From: Paing, Yan <yan.paing@sweco.co.uk>
Sent: 27 September 2023 13:02
To: Gideon.Miller@kent.gov.uk; Daniel.Hoare@kent.gov.uk; David Barker
Cc: Halford, Colin; Liddell, Martin; Barrell, John
Subject: RE: FAO - Daniel Hoare & Gideon Miller- Response To Application Number 22/505852/SUB at Land Off Staple Street Hernhill Kent ME13 9HY
Attachments: 1 in 100 + 40% CC.pdf; 1 in 100.pdf

From: Gideon.Miller@kent.gov.uk <Gideon.Miller@kent.gov.uk>
Sent: 27 September 2023 08:45
To: Halford, Colin <colin.halford@sweco.co.uk>
Cc: Liddell, Martin <martin.liddell@sweco.co.uk>; Barrell, John <john.barrell@sweco.co.uk>; Paing, Yan <yan.paing@sweco.co.uk>; david.barker@wwmartin.co.uk; MattDuigan@Swale.gov.uk; Daniel.Hoare@kent.gov.uk
Subject: RE: FAO - Daniel Hoare & Gideon Miller- Response To Application Number 22/505852/SUB at Land Off Staple Street Hernhill Kent ME13 9HY

Drawing Title: **PROPOSED DRAINAGE LAYOUT SHEET 2**

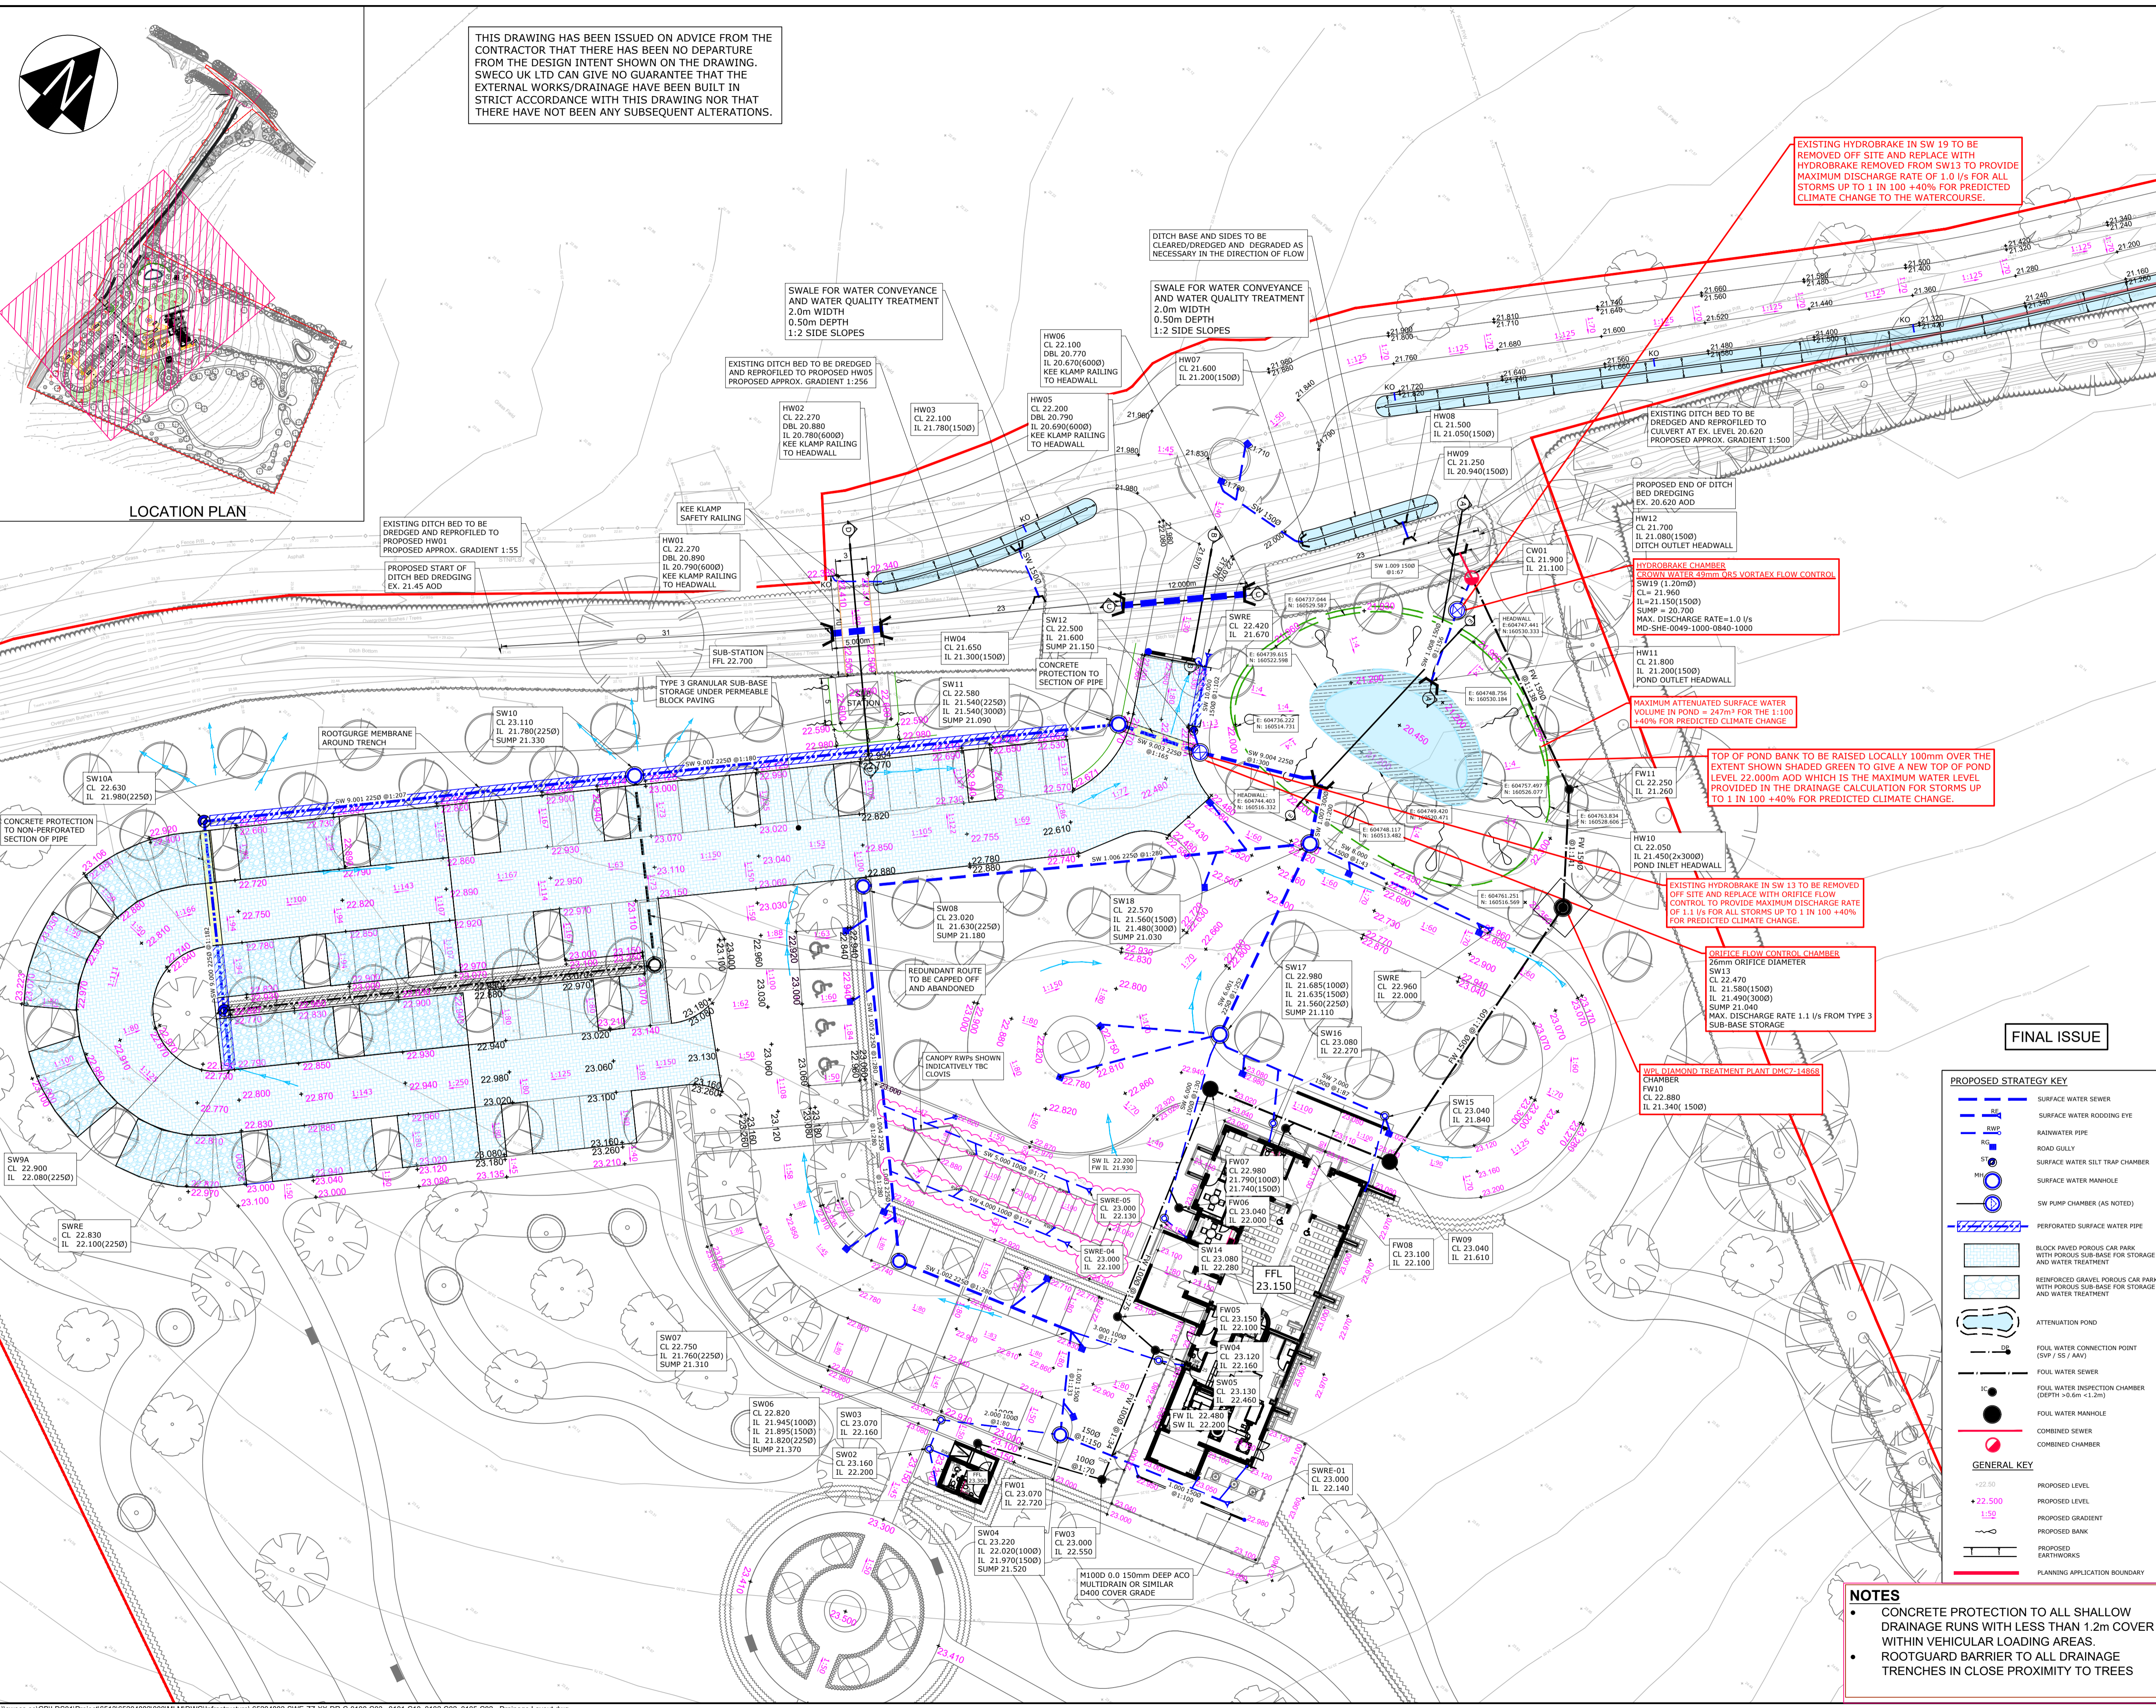
Item 2 - We acknowledge that the hydrobrake at SW19 will restrict all flows to 1 l/s as agreed and, whilst the modelling provided shows several occurrences of flooding with the 100 (+40%) year rainfall event, we would consider these levels to be acceptable given their locations being restricted to the car park.

We also note that whilst a 75 mm orifice plate has been installed at HW13, prior to discharge from the roadside swale into the pond, no modelling for the roadside swale has been provided. We would expect for be provided so that we are able to determine the risk of flooding from this part of the network.

Apologies, please find swale calculations to support orifice diameter of 75mm installed at HW13.

No flooding for 1 in 100 Years, minor flooding for 1 in 100 Years +40% CC.

Item 2 – As agreed in the Teams meeting we have reduced the discharge from the site from 2 l/s to 1 l/s by removing the hydrobrake in chamber SW19 (2 l/s) and replacing with hydrobrake from chamber SW13 (1 l/s). The flow control in chamber SW13 will be replaced with an orifice flow control (1.1 l/s). Drainage calculations for the new set up attached showing that the site discharges surface water to the ditch at 1 l/s for storms up to the 1 in 100 year +40% for climate change.
